DOC16/576219-2  
SSD 7520

**Review of Kurri Kurri Battery Recycling Facility Environmental Impact Statement (SSD 7520)**

## **ATTACHMENT A: OEH REVIEW OF THE PROPOSED KURRI KURRI BATTERY RECYCLING FACILITY, KURRI KURRI (SSD 7520)**

GENERAL SITE LAYOUT (Drainage)

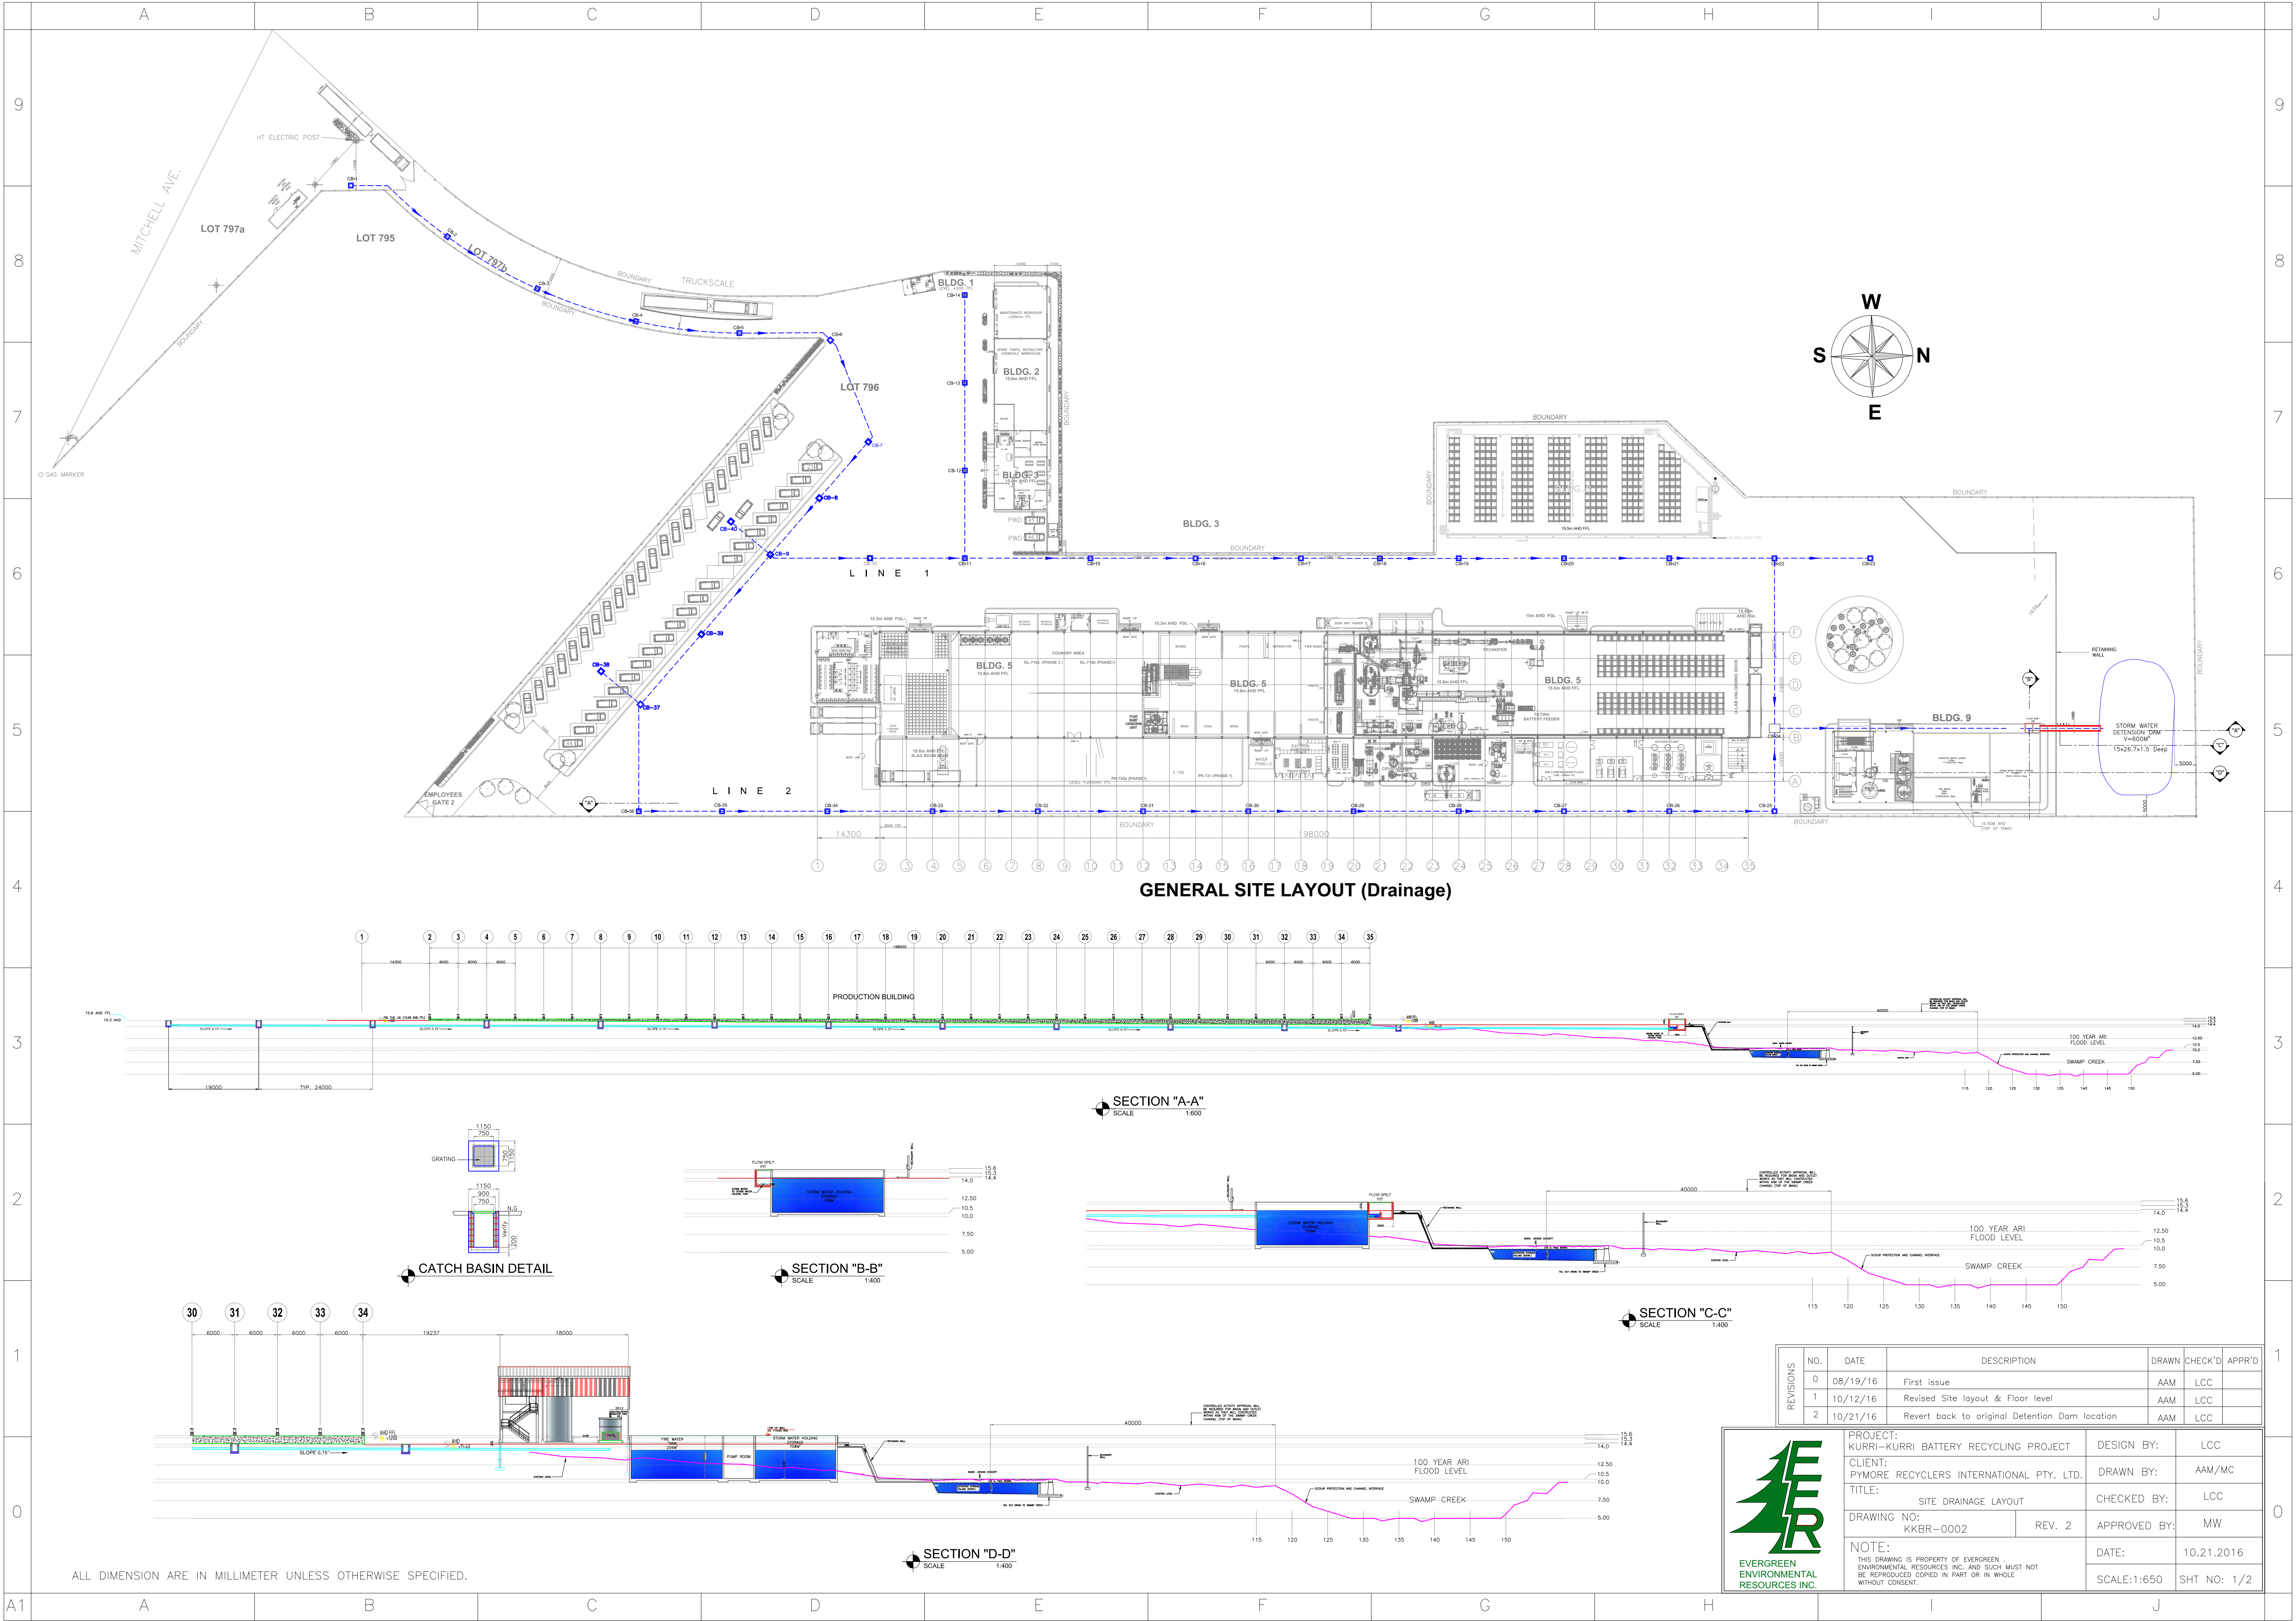
An on-site flood water detention basin is proposed to be located on the floodplain. This will be ineffective in mitigating the full range of events required by Cessnock City Council because the basin is proposed to be located with a crest below the 1% AEP flood level. OEH recommends that the need for this flood water detention basin is discussed with council officers. If it is required to be installed then the detention basin will need to be relocated above the 1% AEP level. Such a move may change the extent of fill and site disturbance currently proposed for this project.
